TRANSPORT FOR LONDON

LOWER THAMES CROSSING – WRITTEN SUBMISSION OF ORAL COMMENTS MADE AT ISSUE SPECIFIC HEARINGS 3 TO 7

DEADLINE 4: 19 SEPTEMBER 2023

A. Works Plans Composite - Sheet 45 (M25 junction 29 and surrounding land)
 (Work Numbers: 9D, 9E, 9F, 9G, 9I, 9J, 9K, 9L, 9P, 9U, 9Z, MU85, MU87, MU88, MU89, MU90, MUT32)

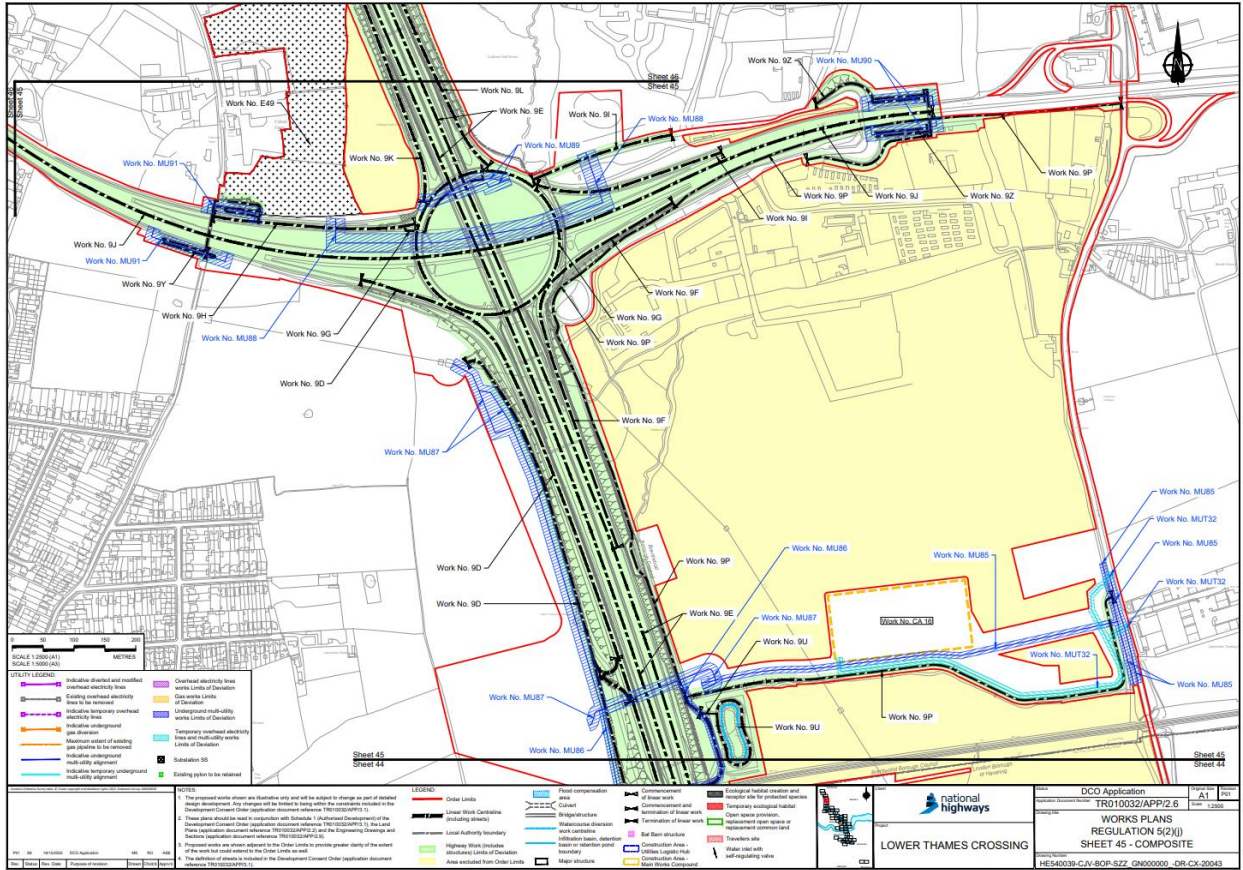
- 2.12 TfL initially noted that there are some enhancements at M25 Junction 29 as part of the Project that had not been covered by the Applicant's overview at the hearing, particularly widening the circulatory carriageway and fully signalling the junction. Building on comments made previously by Essex County Council and others, TfL stressed the importance of works for the Project at M25 Junction 29 being closely coordinated with the proposals for Brentwood Enterprise Park, which also requires enhancements to that junction.

E. Work No. 9Z (Sheet 66) – Walking, Cycling, Horse Rider bridge over A127

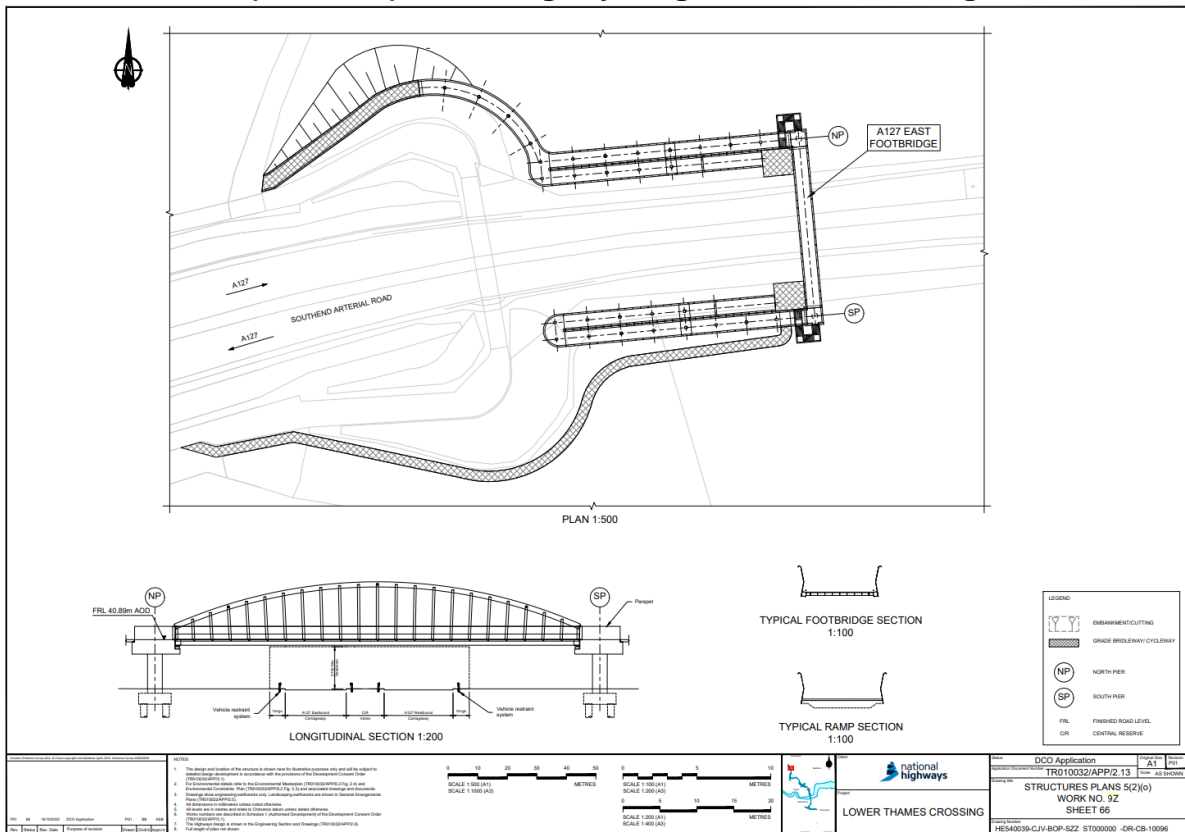
- 2.13 Regarding the changes to the walking and cycling routes in this area, TfL stated that it supports the provision of the walking, cycling and horse-riding bridge that is proposed to the west of M25 Junction 29. This is required to address the severance caused by the new direct links between the M25 to the south and the A127 to the east and west, that require the east-west route for pedestrians and cyclists to move to the northern side of the junction. It is also required given the substantial extra traffic on the A127 that the Project generates, making the existing uncontrolled surface level crossing at the junction with Front Lane and Folkes Lane less safe.

- 2.15 Part (ii) of the ExA's agenda item asked whether there is sufficient design resolution for the structures proposed. TfL explained that it does have some concerns about the design resolution. TfL had been hoping that the design would be developed further in advance of

the DCO application, but TfL understands the Applicant's position, that this will not happen until the contractor develops the design further at the detailed design stage. This makes it very difficult for TfL to understand the maintenance requirements for a structure that TfL, as the local highway authority for the A127, is being asked to maintain. TfL's understanding is that the Structures Plans covering the bridge are illustrative only, as stated in note I on Sheet 76 of the Structures Plans that shows the bridge (REPI-039). The Applicant has advised TfL that the structural form and the materials used could change and this could have a fundamental impact on how TfL would need to maintain that structure, which in turn can impact on the amount of land required around that structure to maintain it. The area available for maintenance around the bridge in the Structures Plans is very tight to the DCO boundary in certain locations on both the north and south sides of the A127. This is a concern that TfL has raised in paragraphs 4.4 and 4.5 of its Written Representation (REPI-304).

- 6.15 TfL added that it has not put any specific requirements on the design of the bridge, other than it needs to follow appropriate highway standards and TfL needs to be able to maintain it in an efficient way. TfL suggested that the Applicant could explore alternative designs
